**To: All Staff**  
**From: Environmental Health**  
**Date: March 21, 2025**  
**Subject: SP-25-00005**

HANSON ROAD SHORT PLAT
 PART OF SECTION 11, T. 17 N., R. 17 E., W.M.
 KITTITAS COUNTY, WASHINGTON

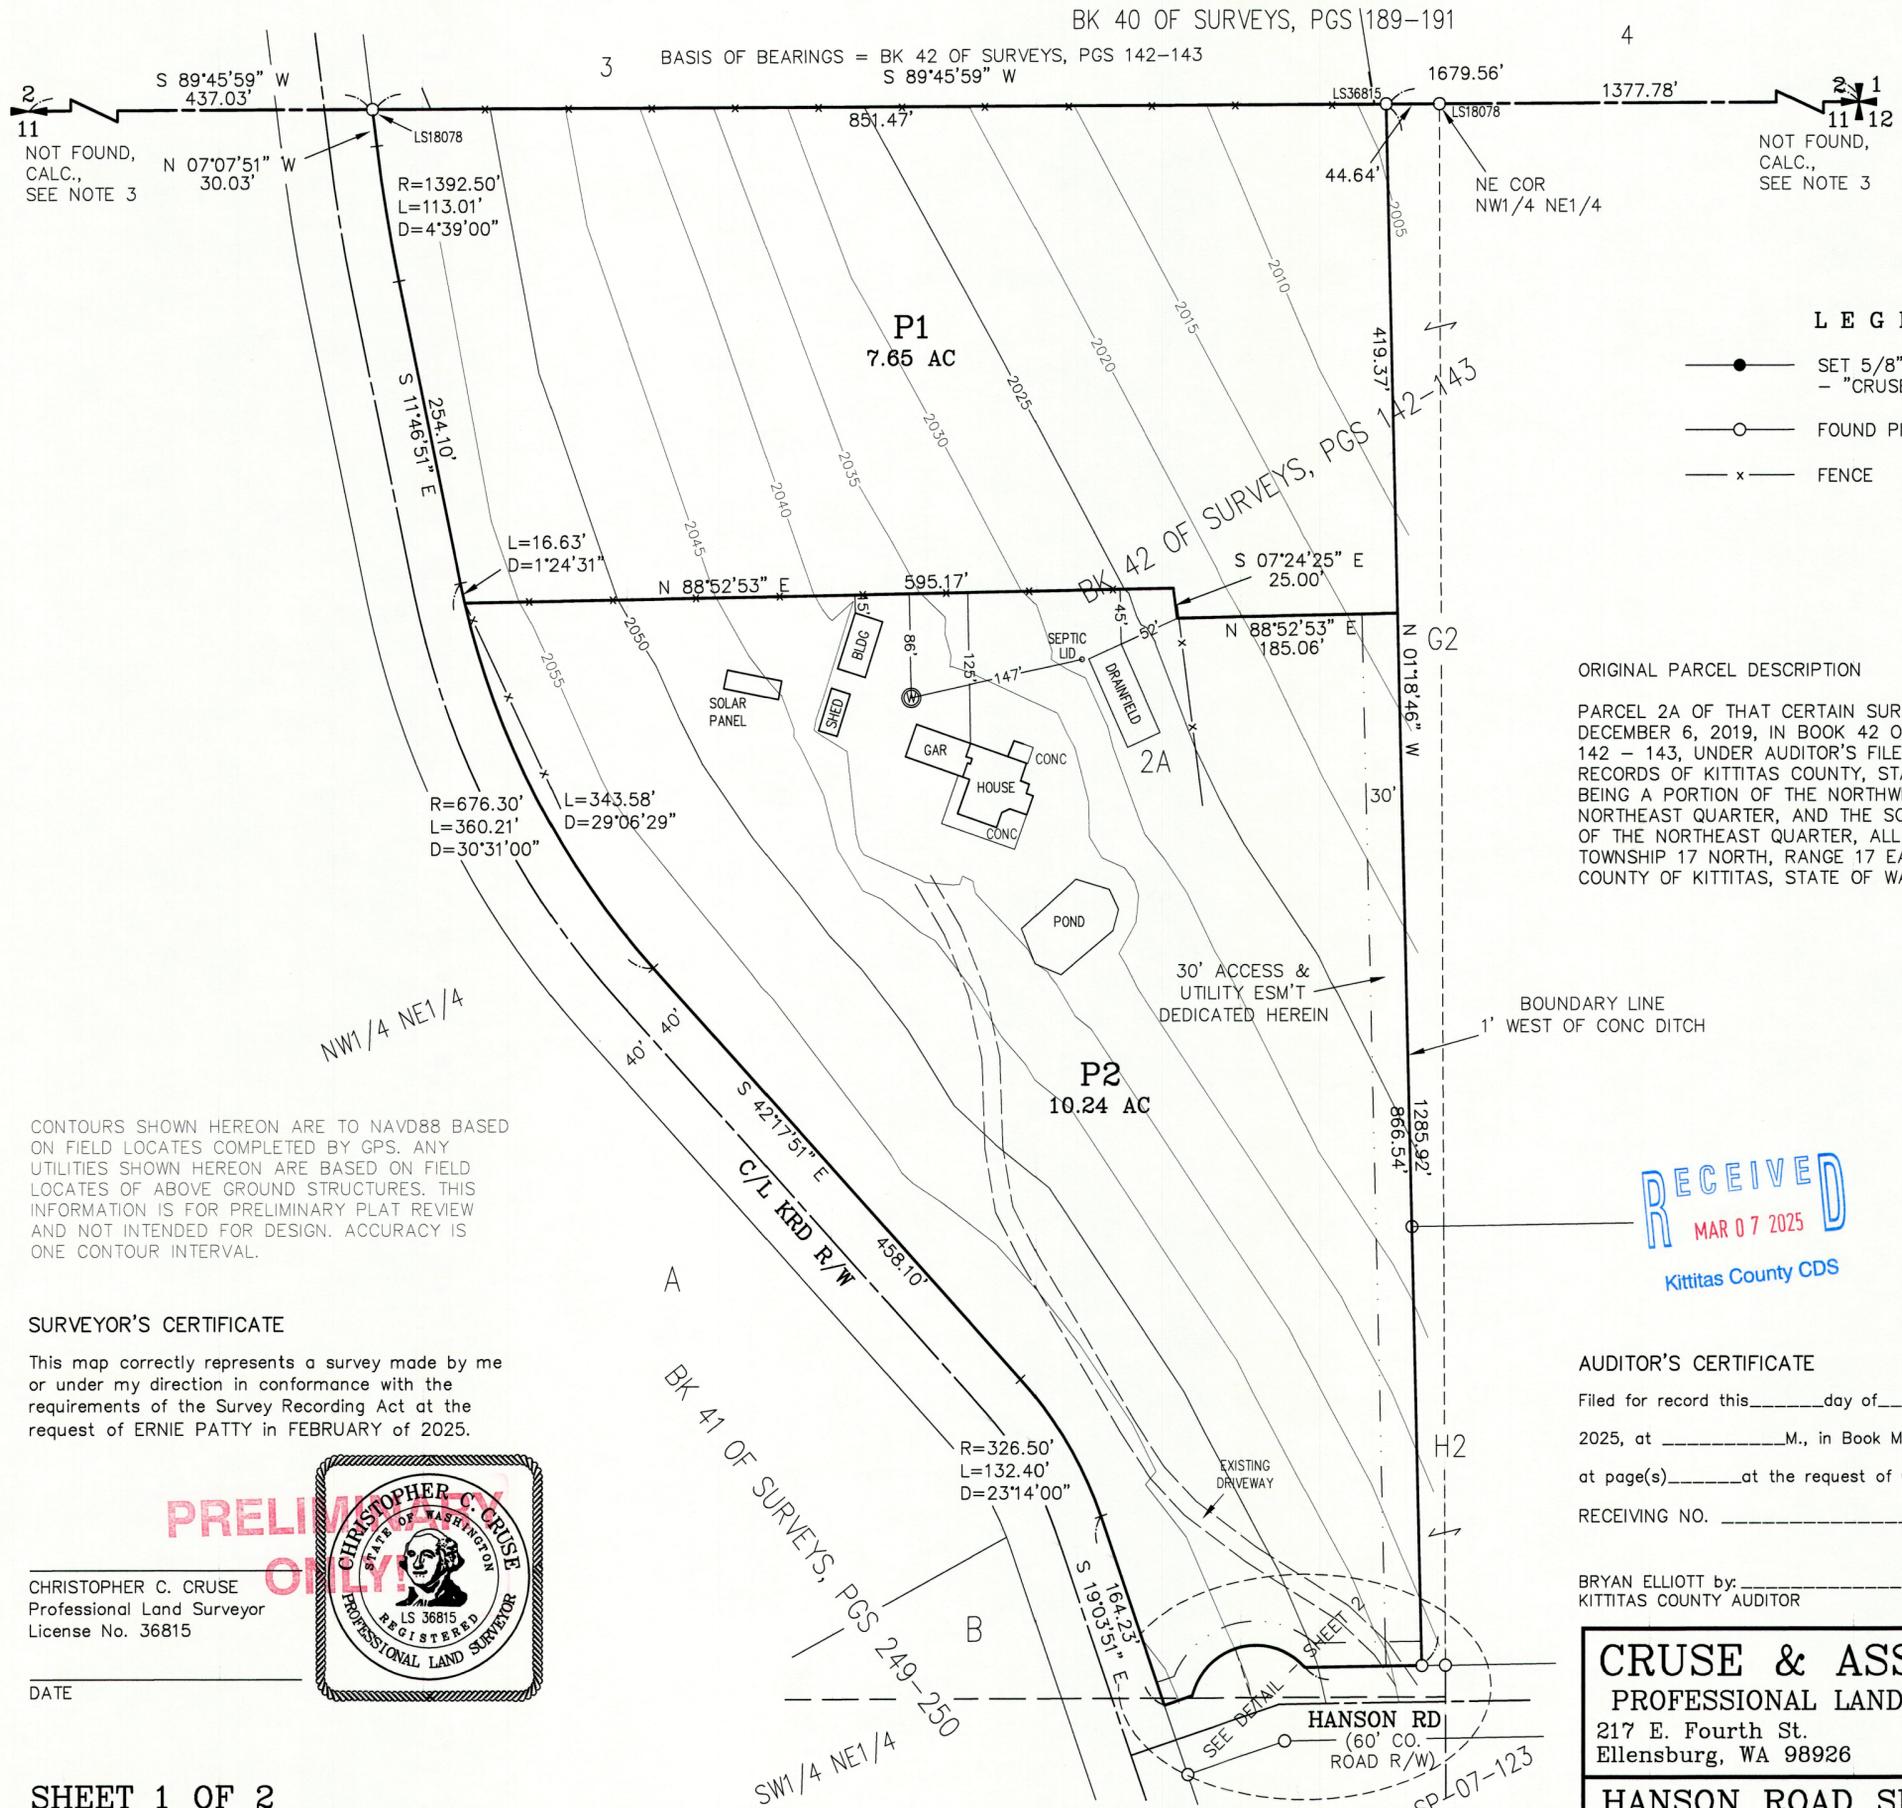
<b>Drinking Water</b>	<ul style="list-style-type: none"> <li>• The proposed shared well does not meet requirements found in WAC 246-272A-0320(2)(b) for subdivisions with individual wells proposed.</li> <li>• The well log was recorded within the last 10 years. Well Log is attached.</li> <li>• Current well water quality test including passing bacteriological (1 year) and nitrate (3 years) must be submitted to KCPHD.</li> <li>• Shared well users agreement recorded with the County Auditor must be submitted to KCPHD.</li> </ul>
<b>Wastewater</b>	<ul style="list-style-type: none"> <li>• Lot P1 will require a soil log to be evaluated by KCPHD.</li> <li>• Lot P2 has an approved OSS permit OS-17-00239.</li> </ul>
<b>Food Safety</b>	<ul style="list-style-type: none"> <li>• NA (DS)</li> </ul>
<b>Living Environment</b>	<ul style="list-style-type: none"> <li>• NA (DS)</li> </ul>
